**STORMWATER MANAGEMENT PLAN CHECKLIST**

**SF-20-014 and EGP-20-004**

**CLAREMONT BUSINESS PARK 2 FIL. NO. 1
LOT 7 SITE GRADING PLAN**

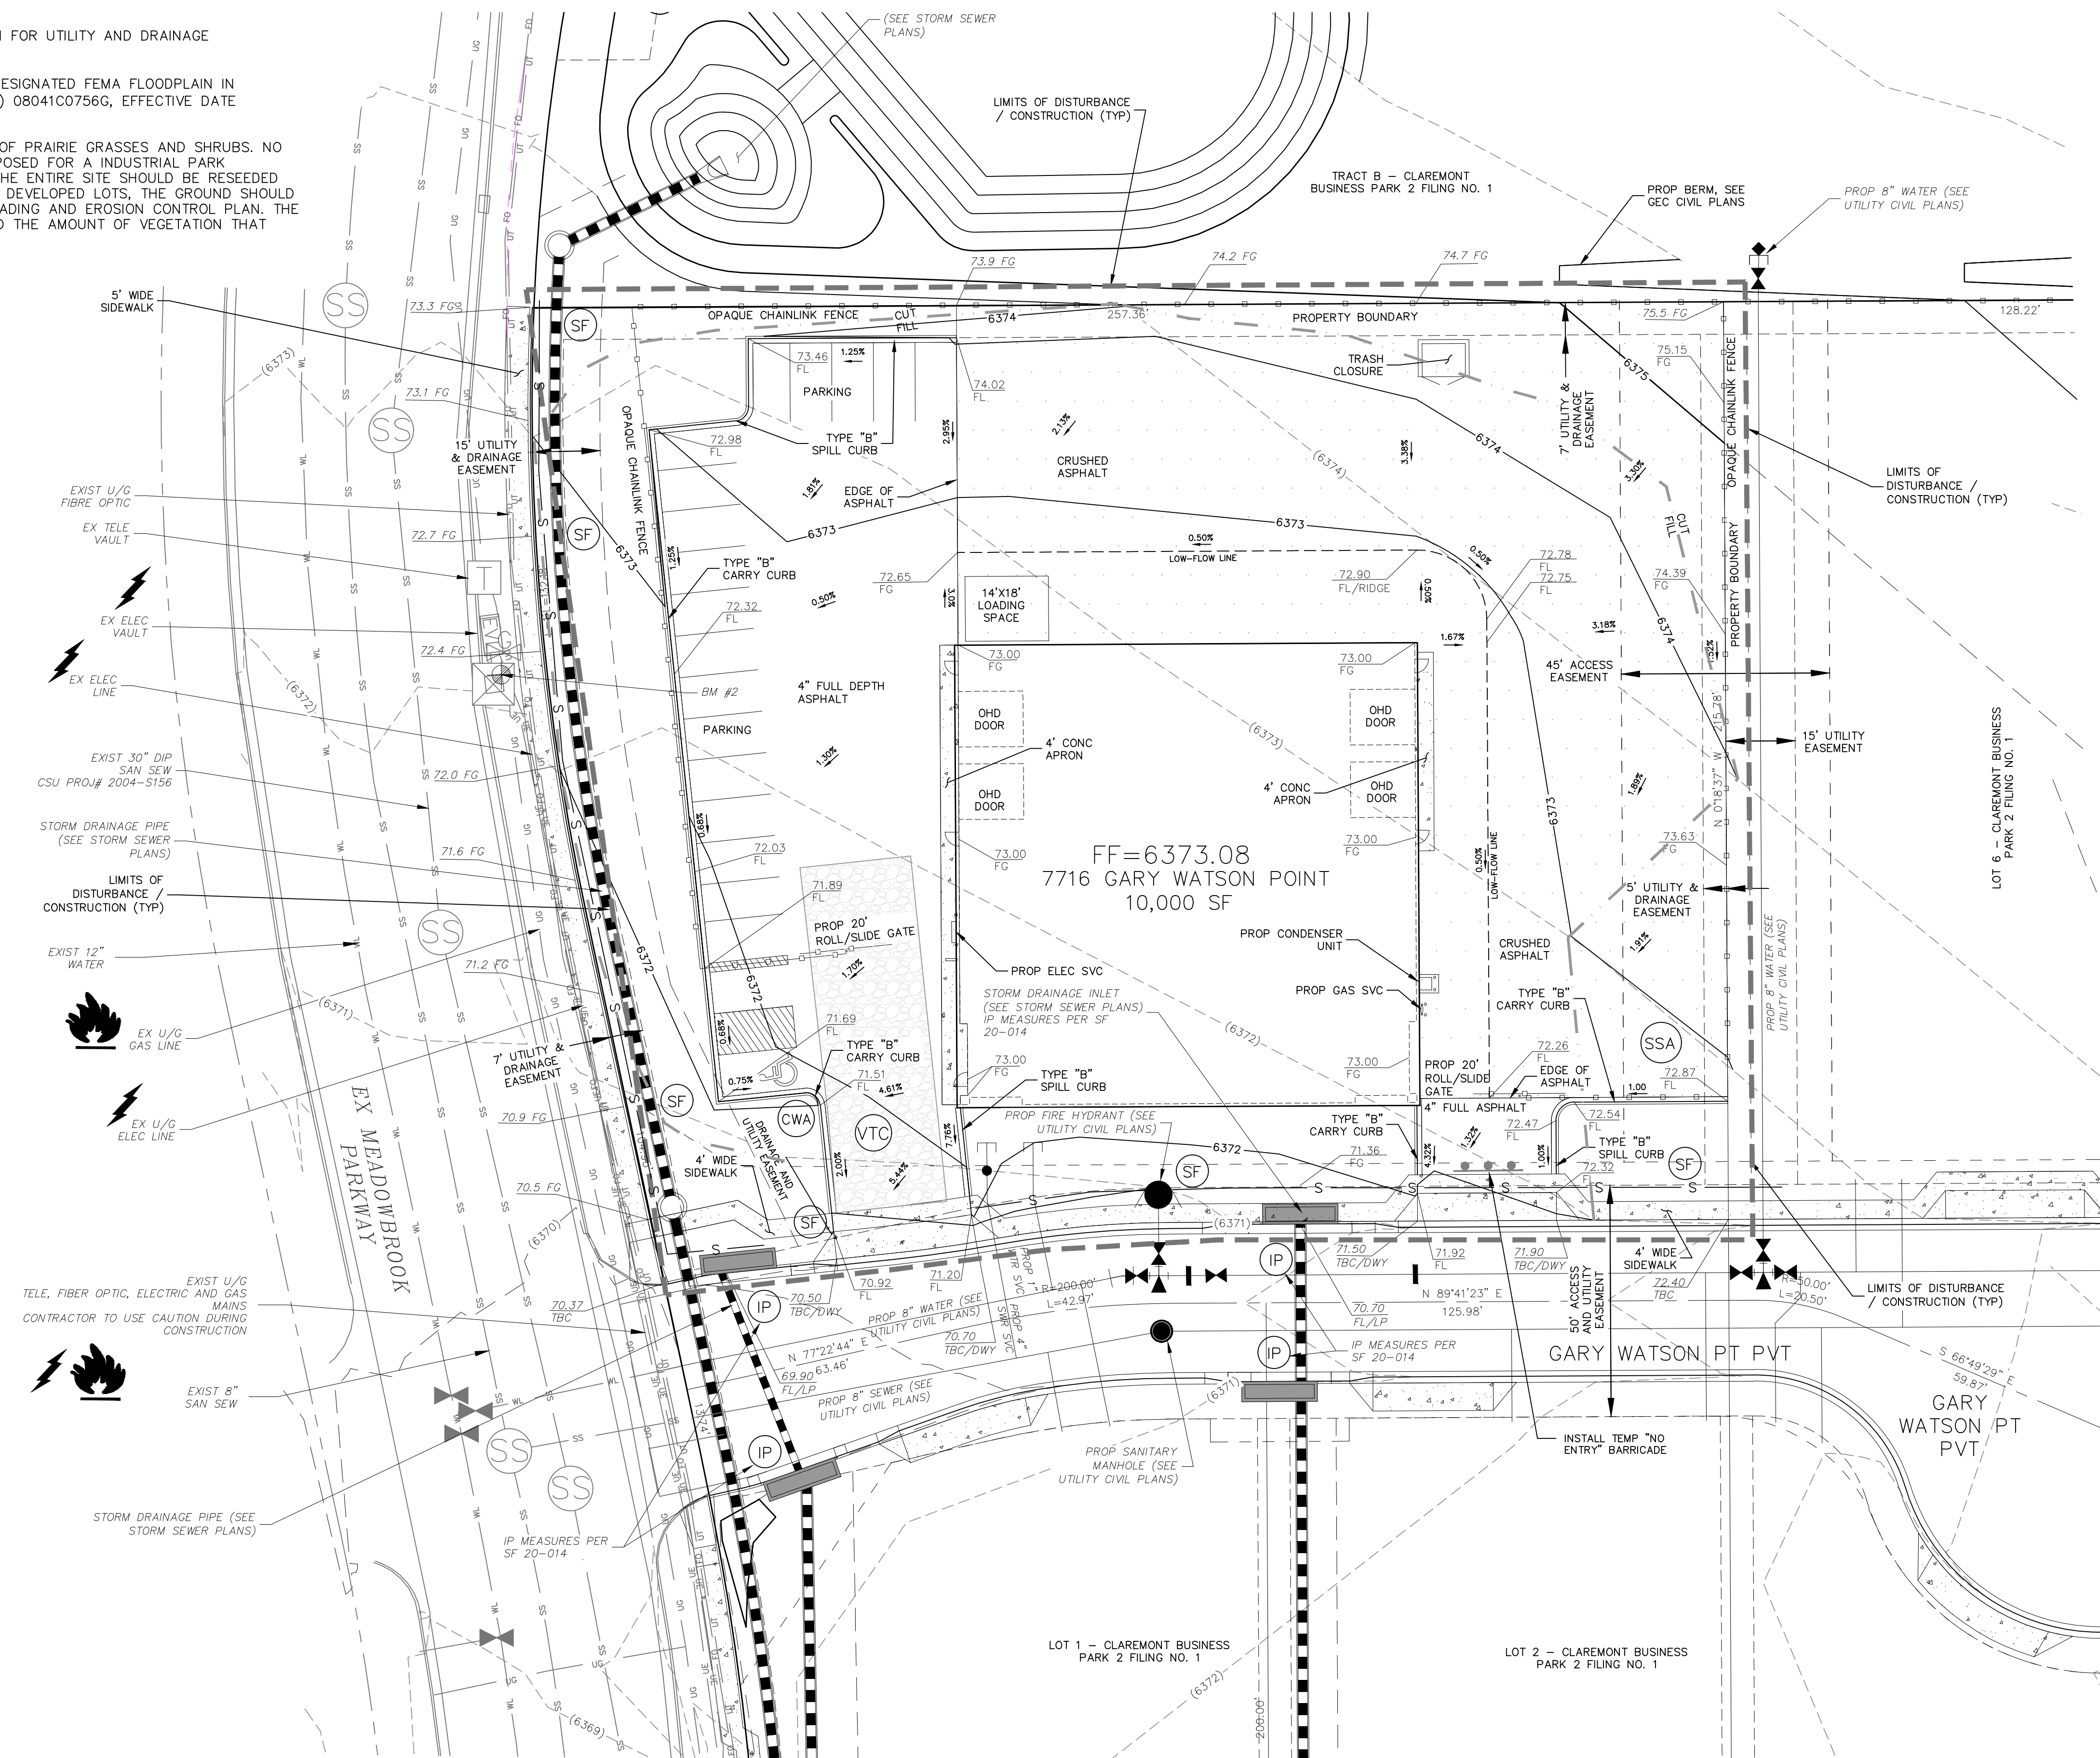
<b>Please note: all items above must be addressed. If not applicable, explain why, simply identifying "not applicable" will not satisfy CDPHE requirement of explanation.</b>		
<b>2. ADDITIONAL REPORTS/PERMITS/DOCUMENTS</b>			
a	Grading and Erosion Control Plan (signed) <b>Not signed at this time</b>	X	
b	Erosion and Stormwater Quality Control Permit (ESQCP) (signed)	X	
<b>3. Applicant Comments:</b>			
a	5. No Phasing is anticipated
